To: Lisa Gish
Engineering Inspector I
El Paso County Department of Public Works

From: Eric Gunderson, P.E.,
Kimley-Horn and Associates, Inc.

Date: April 6, 2023

Subject: Widefield Parks and Recreation – Recreation Center – Pond Outlet Structure

C7.5

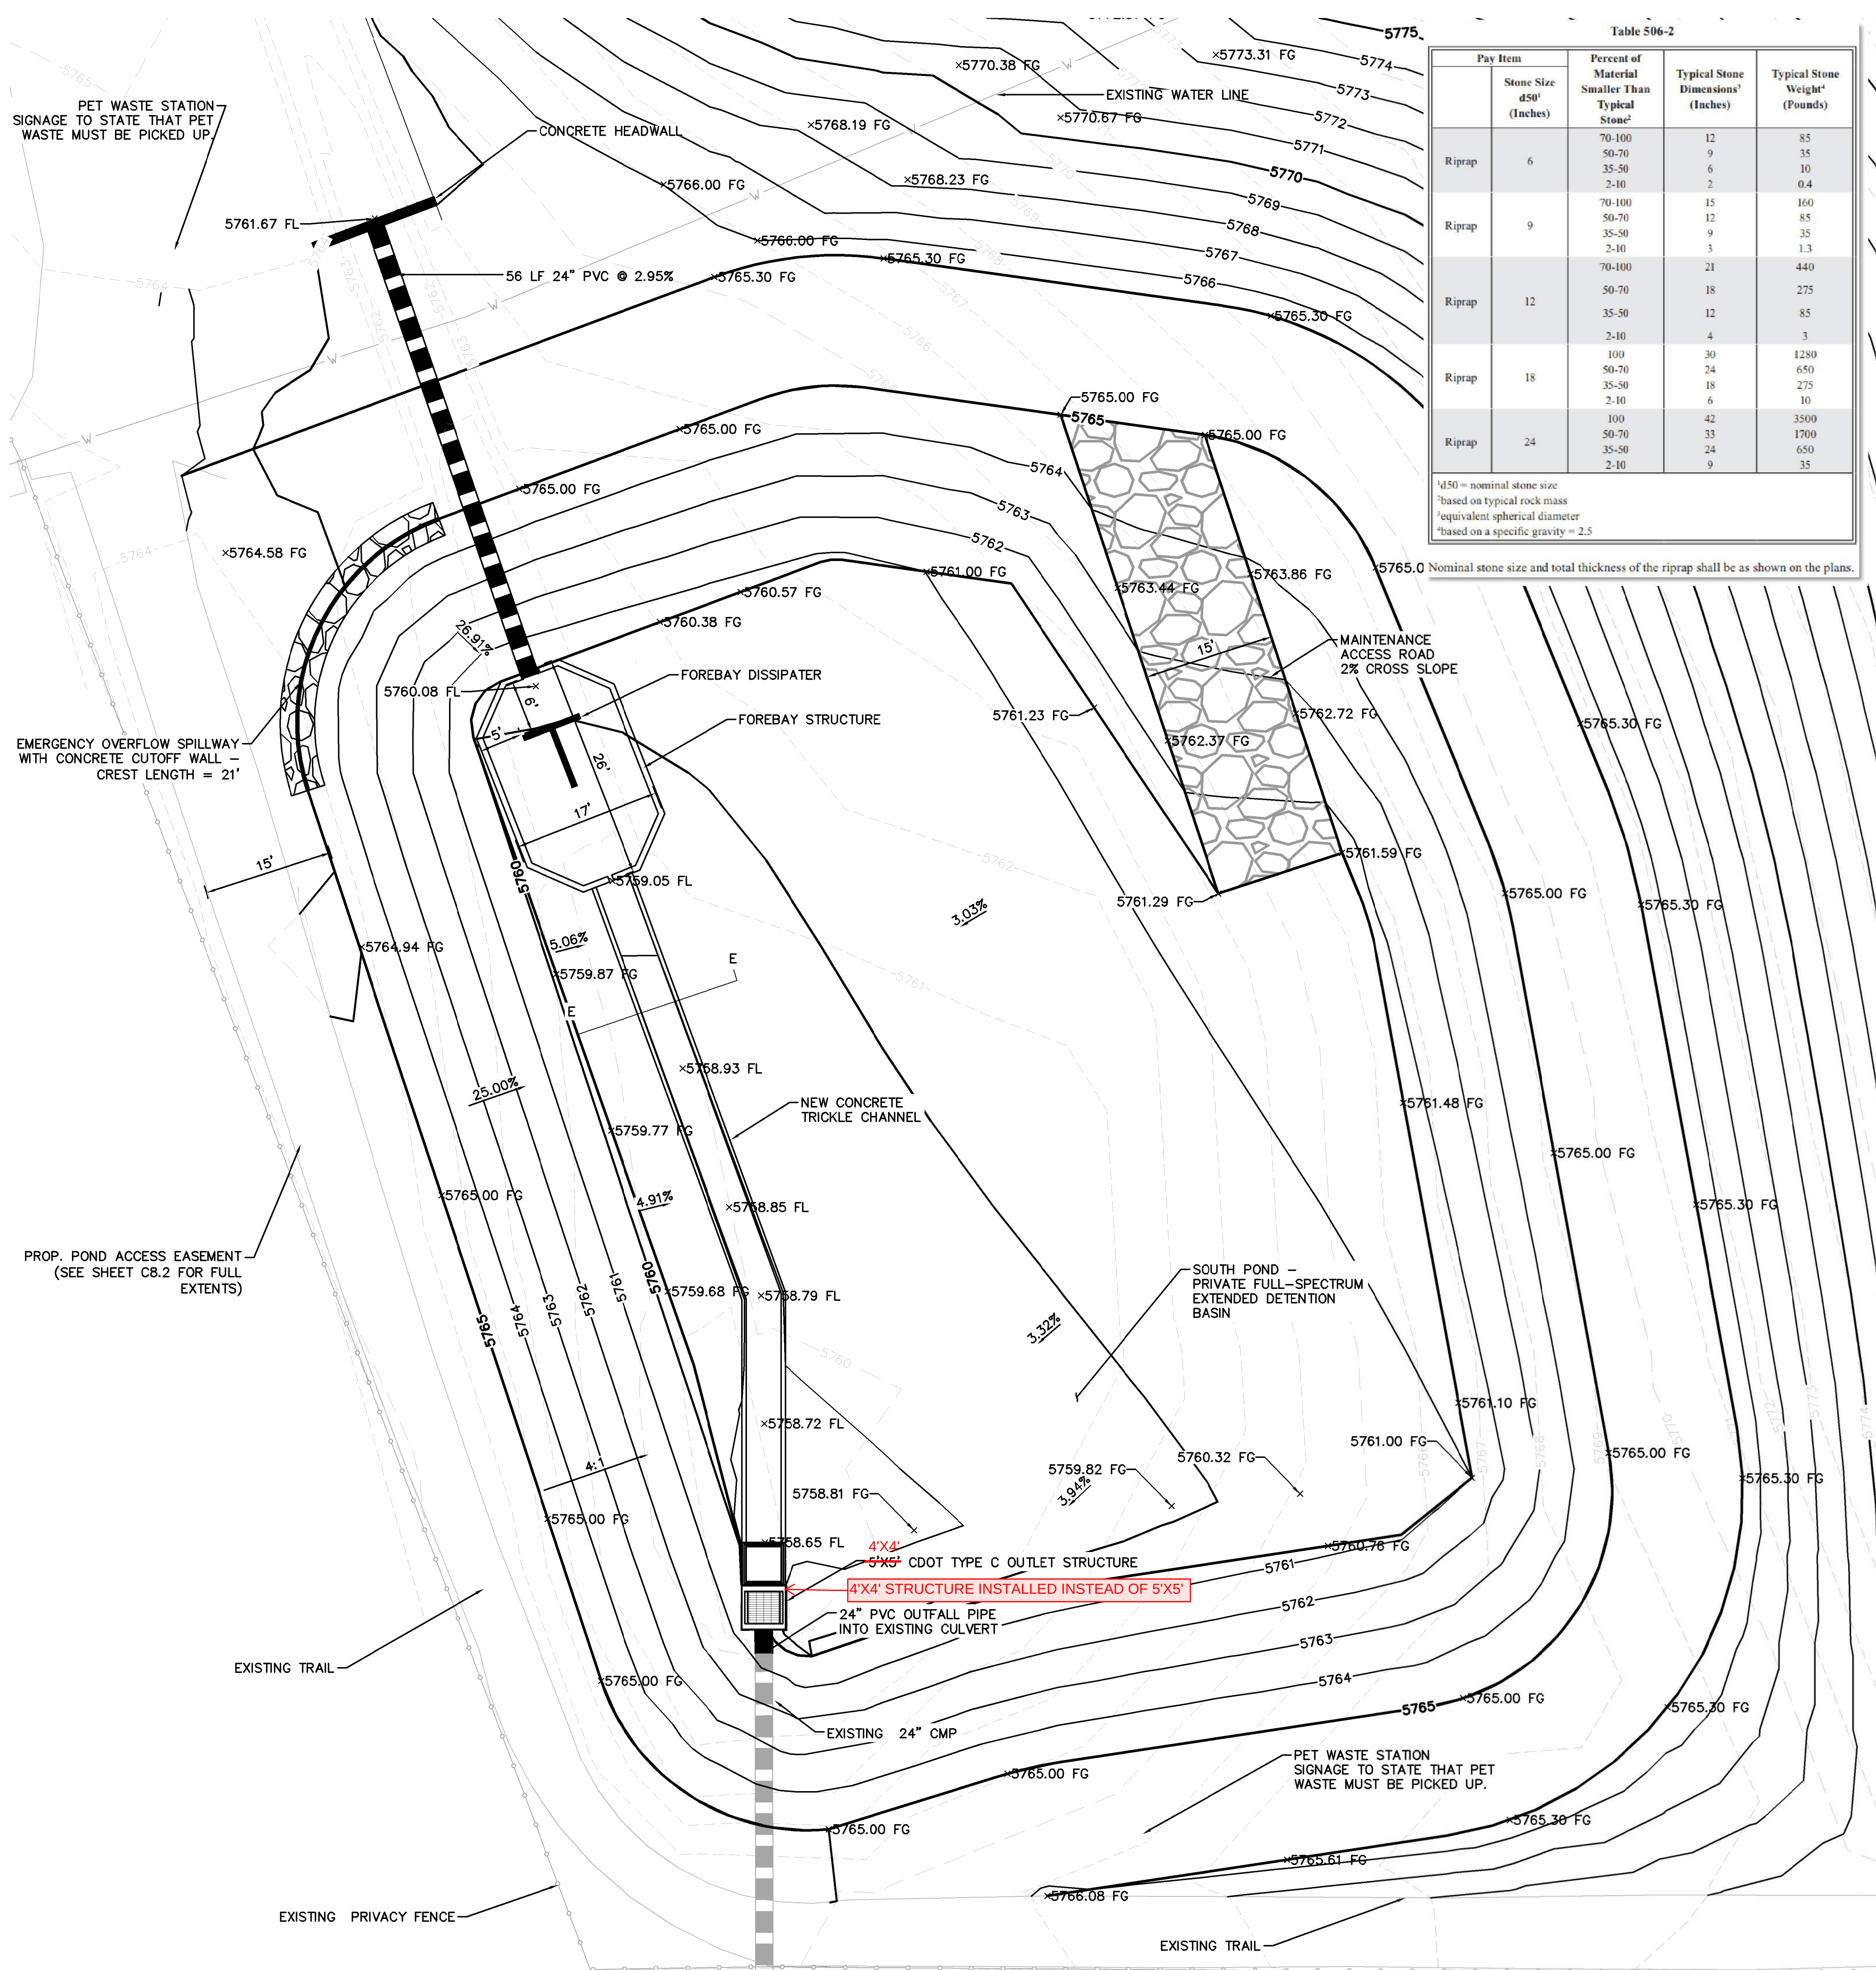
Based upon an email received by Kimley-Horn from Lisa Gish dated April 4, 2023 4:09PM, it is understood the proposed outlet structure in the extended detention basin at the subject site has been constructed differently than the approved plans dated 2/28/23. The approved plans call for a 5'x5' Type C CDOT structure with 4:1 sideslope/grate. Based upon the referenced email from the County, it is understood the structure was installed at 4'x4' and was installed with a flat top instead of the 4:1 sloping grate.

Attached is a markup of the approved pond plans showing the as constructed condition based upon the information above. Kimley-Horn redesigned the outlet structure using this information and the MHFD analysis has been included in this memo, following the plan markup.

Kimley-Horn proposes lowering the restrictor plate on the outlet pipe 6" for a total of 12" of clearance as noted. This will maintain the appropriate pre-development vs. post development flow ratios and drain times to be in compliance with the approved final drainage report for the project.

Based upon the information above and analysis performed herein and the adjustment to the restrictor plate, the change in size and slope of the outlet structure is acceptable to the engineer of record.
